<b>Application Ref:</b>	2025/0357			 Ribble Valley Borough Council <small>www.ribblevalley.gov.uk</small>
<b>Date Inspected:</b>	29.5.25	<b>Site Notice:</b>	29.5.25	
<b>Officer:</b>	Stephen Kilmartin			
<b>DELEGATED ITEM FILE REPORT:</b>				<b>APPROVAL</b>

<b>Development Description:</b>	Proposed change of use from farm dwelling to offices for Ribble River Trust.
<b>Site Address/Location:</b>	Horrocksford Old Hall Farm West Bradford Road Clitheroe BB7 4QD

Client RIBBLE RIVERS TRUST	Scale NOTED Date JUNE 25 Drawn WS	Drawing title ACCESS DETAILS
Job title ALTERATIONS HORROCKSFORD FARM HOUSE	<b>1200 D026</b>

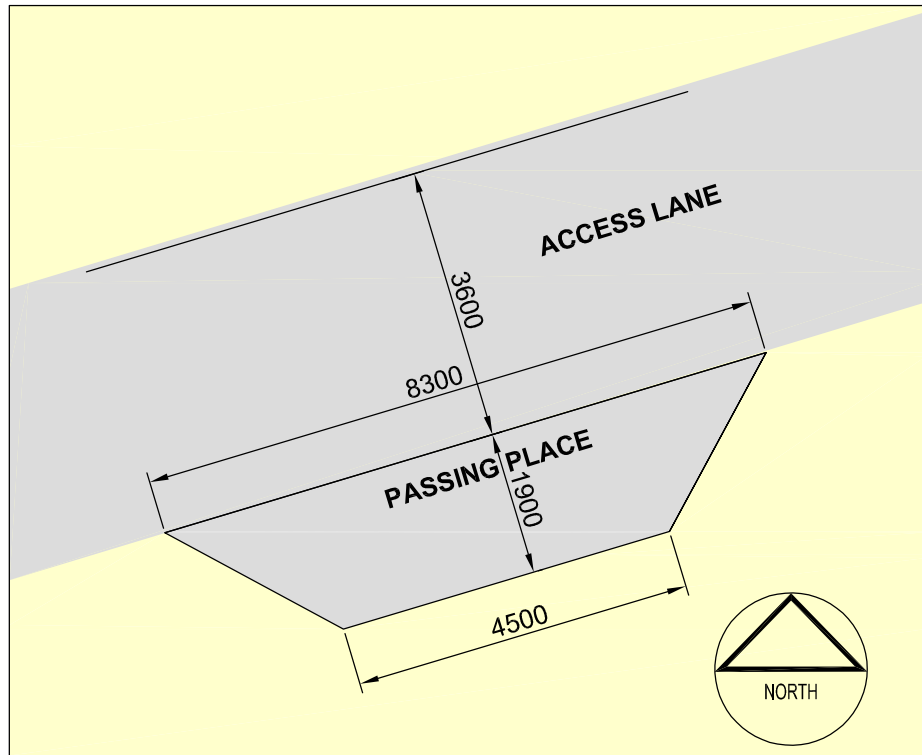
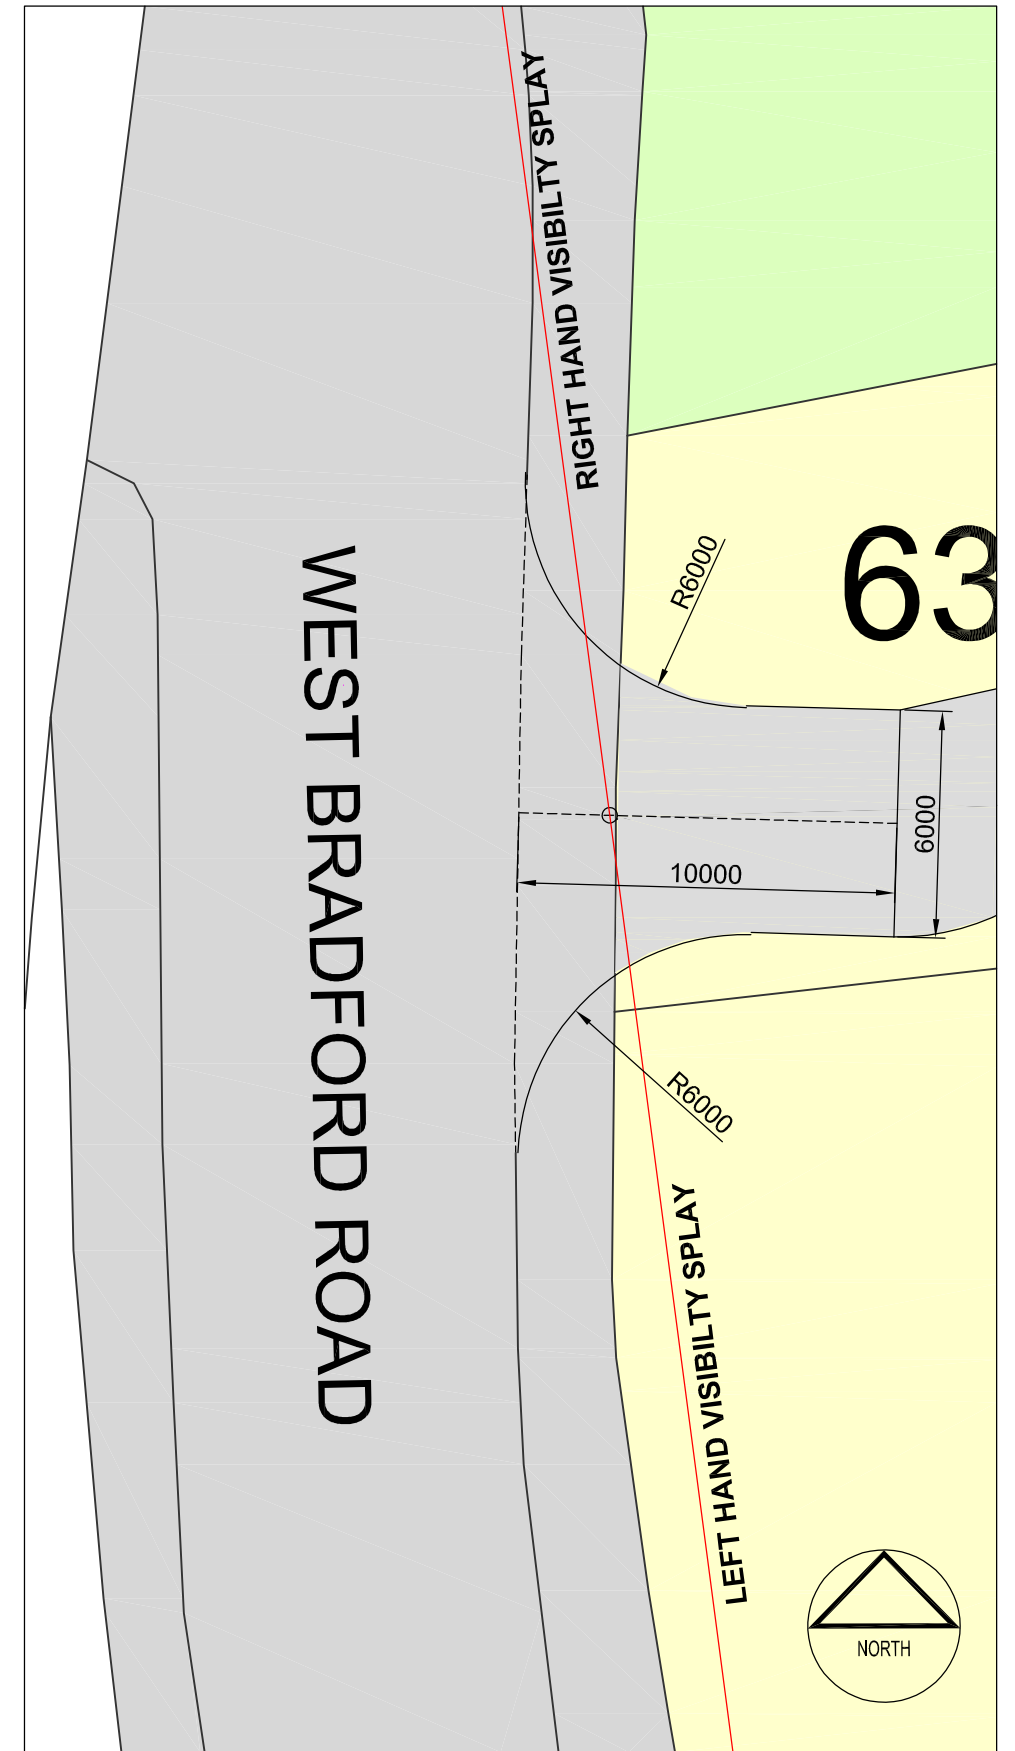
*The LHA are aware that the site will continue to be accessed off West Bradford Road which is a C classified road subject to a 30mph speed limit, an agricultural farm access was approved under planning permission 3/2015/0954, which the applicant intends to continue to use to provide access to site. However, a detailed access plan should be submitted as part of the application, showing the widths of the access and access road so the LHA can review if the access is an acceptable width to support the intensification of its use following the development.*

*A swept path analysis for a twin axel refuse vehicle should be provided or a 6m wide access for a minimum of 10m into the site supported by a 6m radius should be provided to support ingress and egress of either a larger vehicle that would be expected at the site such as a refuse collection vehicle or for allowing two way movement of vehicles.*

*An internal access road is proposed between the site access and the car parking provisions, which was initially considered as part of application 3/2015/0954 to support agricultural access to the site. Given the intensification of the proposal and change of use the LHA would require a detailed plan showing the full width of the internal access road, the internal access road should support two way movement as such it should be at least 5.5m wide for its entire length.*

*The site would also benefit from pedestrian facilities in line with inclusive mobility guidance which may reduce the reliance on private vehicles as such the site would benefit from 2m wide footway provisions from the access into the site.*

It is noted that the Local Highways Authority have stated that the site would benefit from the provision of a 2m wide footway provisions from the access into the site. However, the local planning Authority considers that this would exacerbate the visual impact of the access track to a level that would be considered unacceptable, largely by virtue of the resultant suburbanising visual effect upon the defined open countryside. With the cumulative visual effect of a formal access track and 2m wide footway considered to be both anomalous and incongruous when taking account of the character of the area.

It is further noted that in respect of the existing access point, the Local Highways Authority have requested that *'further detailed assessments are required to ensure its suitability for intensified use, including swept path analysis and/or width measurements to support safe vehicle movements'*. Further stating that *'future expansion plans must be carefully considered when the latter stages come forward for consideration by the LHA in relation to parking capacity and operational needs to support long-term site development without compromising traffic flow or highway safety'*.

However, in respect of the above matters, the existing access and track have previously been consented pursuant to extant planning permission 3/2015/0954. Notwithstanding this matter, 'future expansion plans' do not form part of the current application and as such, should further applications be received the authority considers that the access point should be assessed at that future stage when details of any future 'expansion' and potential resultant impacts are known.

VERTICAL SECTION

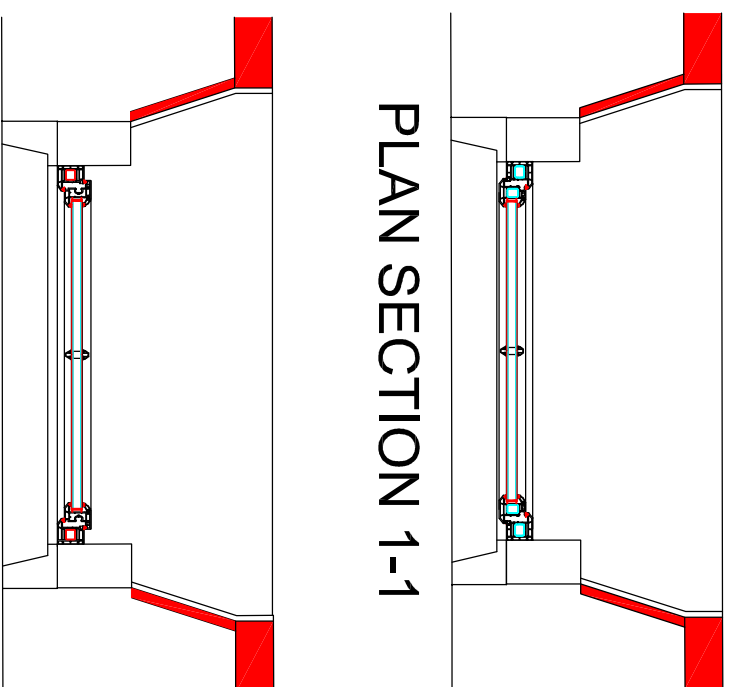
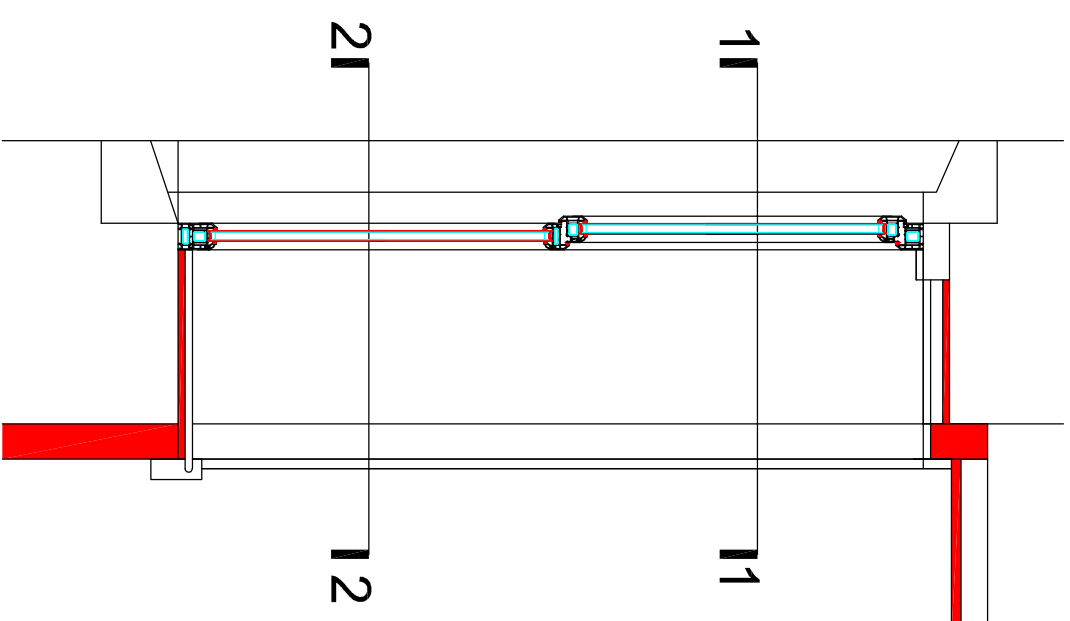
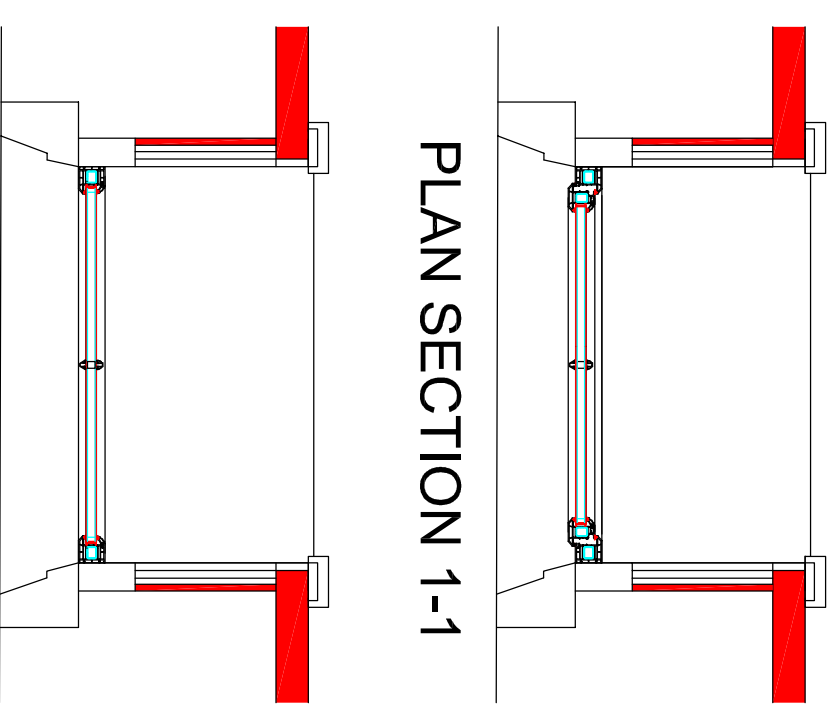
In respect of the proposed 'replacement of existing timber windows with UPVC windows to match existing UPVC windows'. The authority would not normally consider that the removal of the existing timber windows and installation of replacement UPVC Windows to be an appropriate approach. However, given the majority of the windows already installed upon the building are UPVC and given the increased impetus to bring the building into a functional use, the authority considers that the harm resultant the removal and replacement of the existing timber windows would be significantly outweighed by securing and enable a viable use of the building for commercial purposes. The submitted details further propose the replacement of existing 'rooflights' with that of 'pre-finished' metal-clad rooflights. No details have been provided in respect of
